SITE DEVELOPMENT PLAN AMENDMENT FOR THE HAROLD D. THOMPSON REGIONAL WATER RECLAMATION FACILITY PHOSPHORUS CONTROL FACILITIES

FOR THE LOWER FOUNTAIN METROPOLITAN SEWAGE DISPOSAL DISTRICT

SEPTEMBER 2017

**PHOSPHORUS BUILDING
GRADING AND EROSION CONTROL PLAN
SITE DEVELOPMENT AMENDMENT FOR THE
HAROLD D. THOMPSON REGIONAL WATER RECLAMATION FACILITY
LOWER FOUNTAIN METROPOLITAN SEWAGE DISPOSAL DISTRICT**

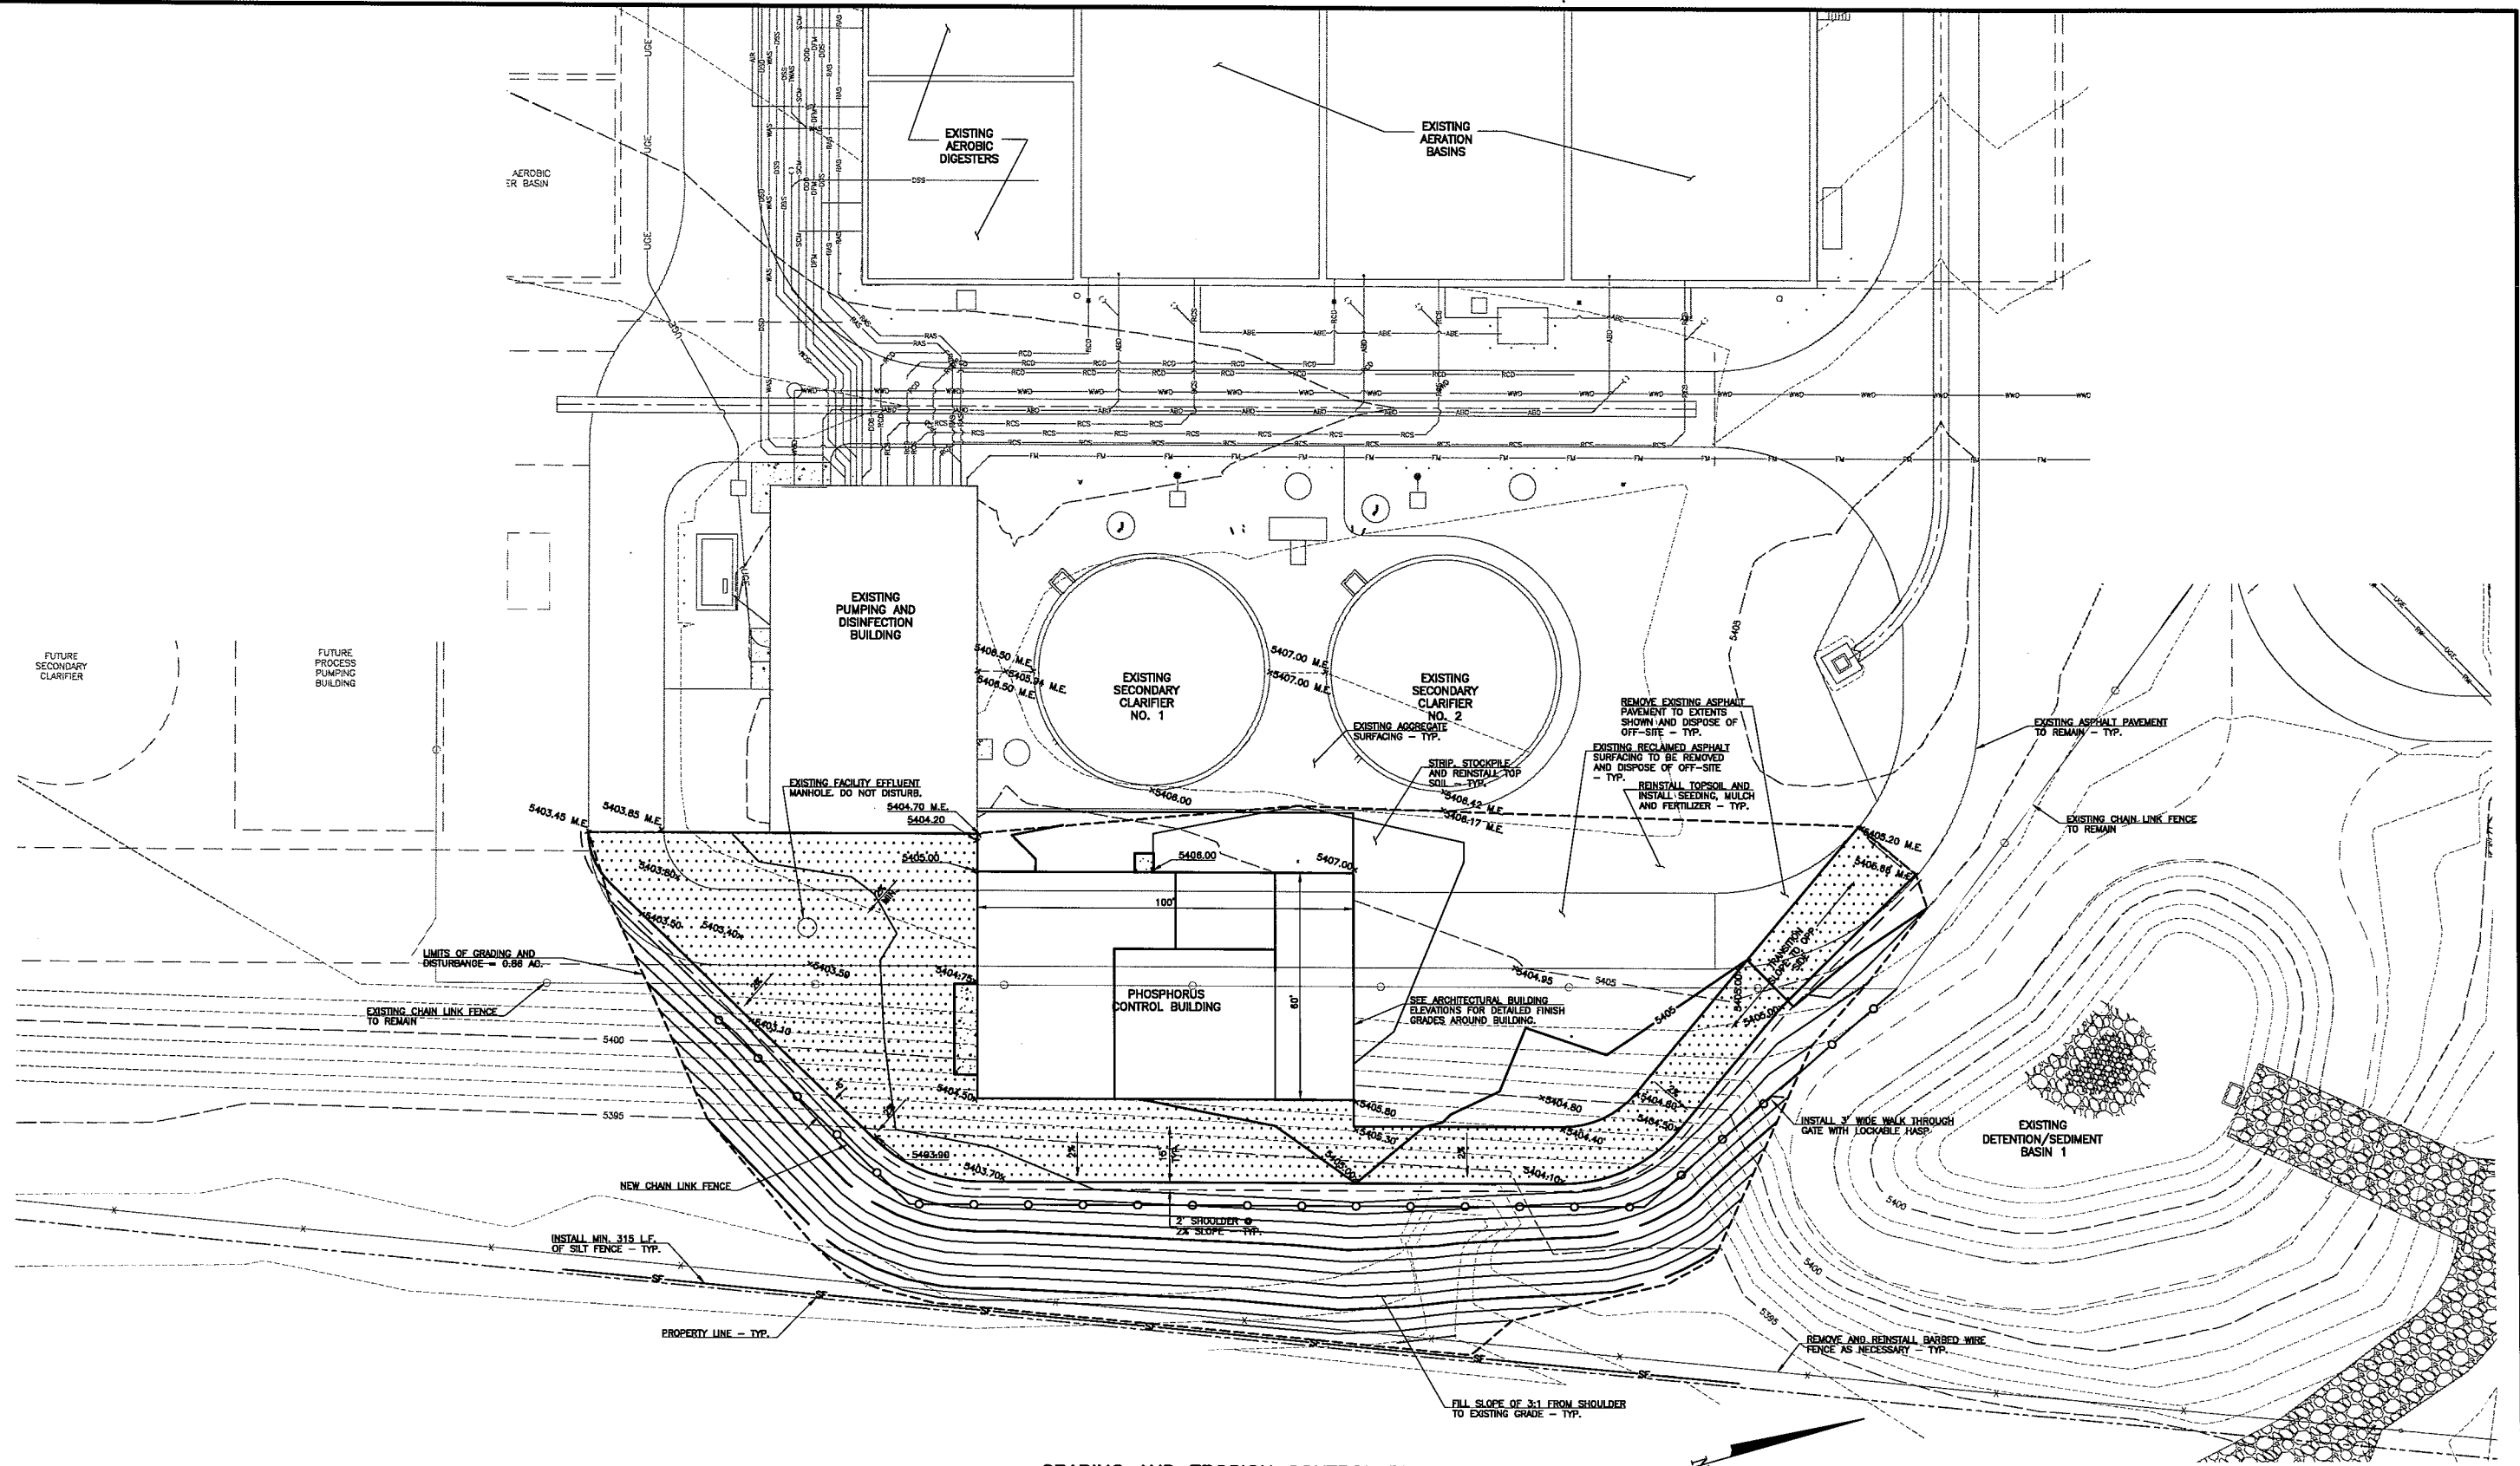
Add the BMP details with the standalone GEC plans.

Provide WQ/Detention for the proposed improvements. Construction details for any proposed drainage improvements must be included in the standalone GEC plans.
